Presbyterian at Forest Hills

Administrative Amendment Request

Project #PR- 2021-005184

Transportation Development Comments:

ARCHITECTURAL
 SITE PLAN

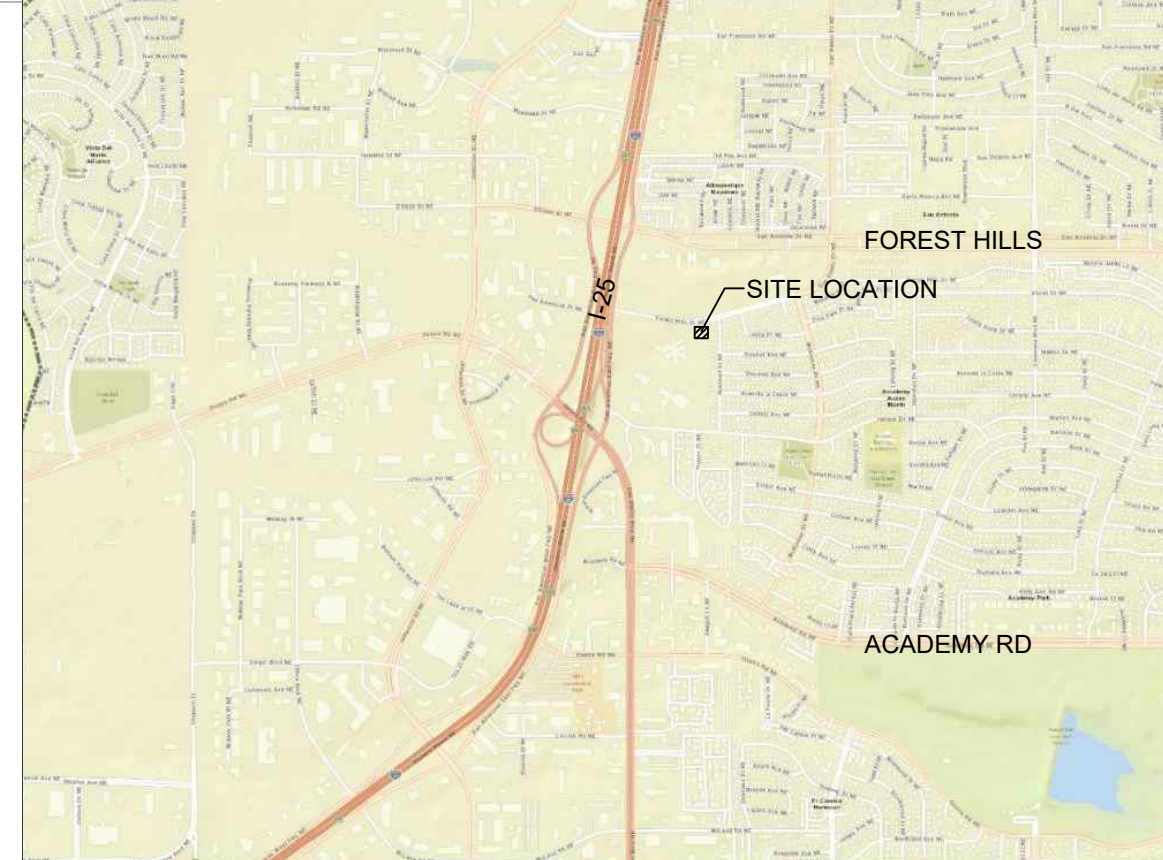
1. Receive Solid Waste approval for this new layout. **Approved, See attached.**
2. Call out existing sidewalk width along frontage of the site. **See keyed note #16 AS101**

C1 TRASH ENCLOSURE
1/8" = 1'-0"

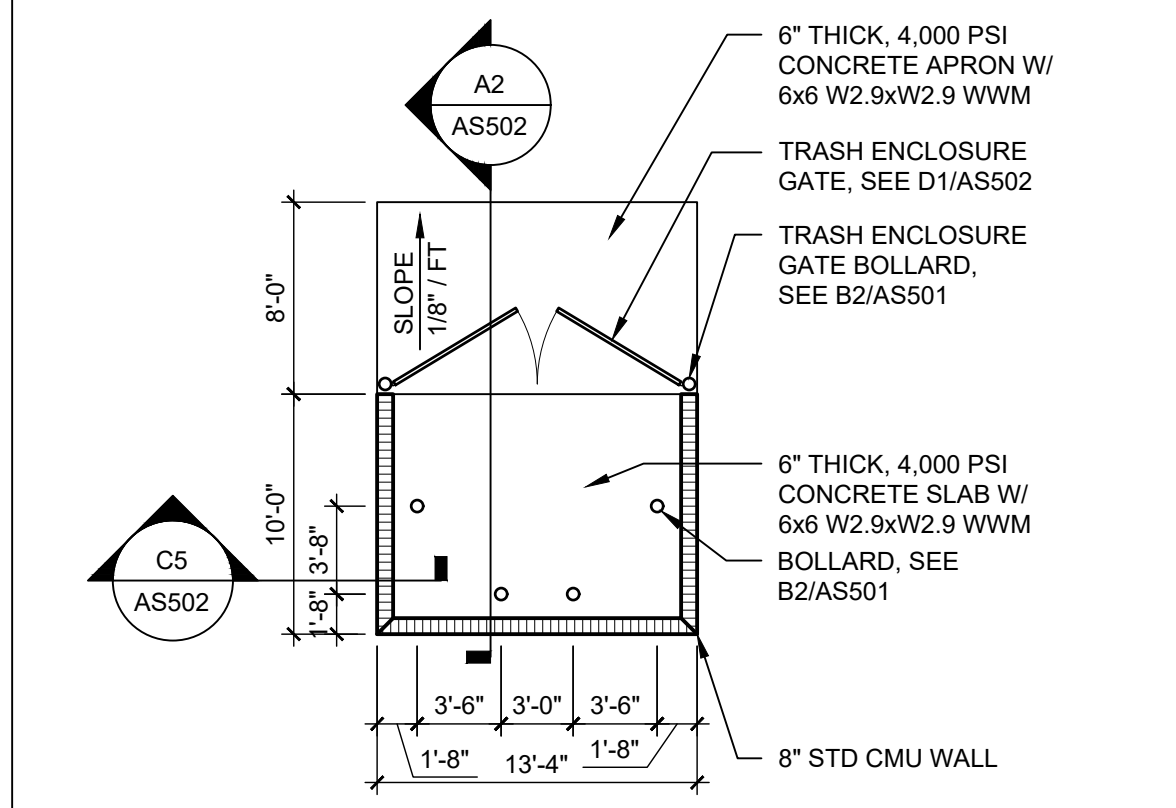
6. Call out any bollards on site plan if applicable since they are shown in the details. **The bollards only exist at the trash enclosure. See detail C1/AS502**
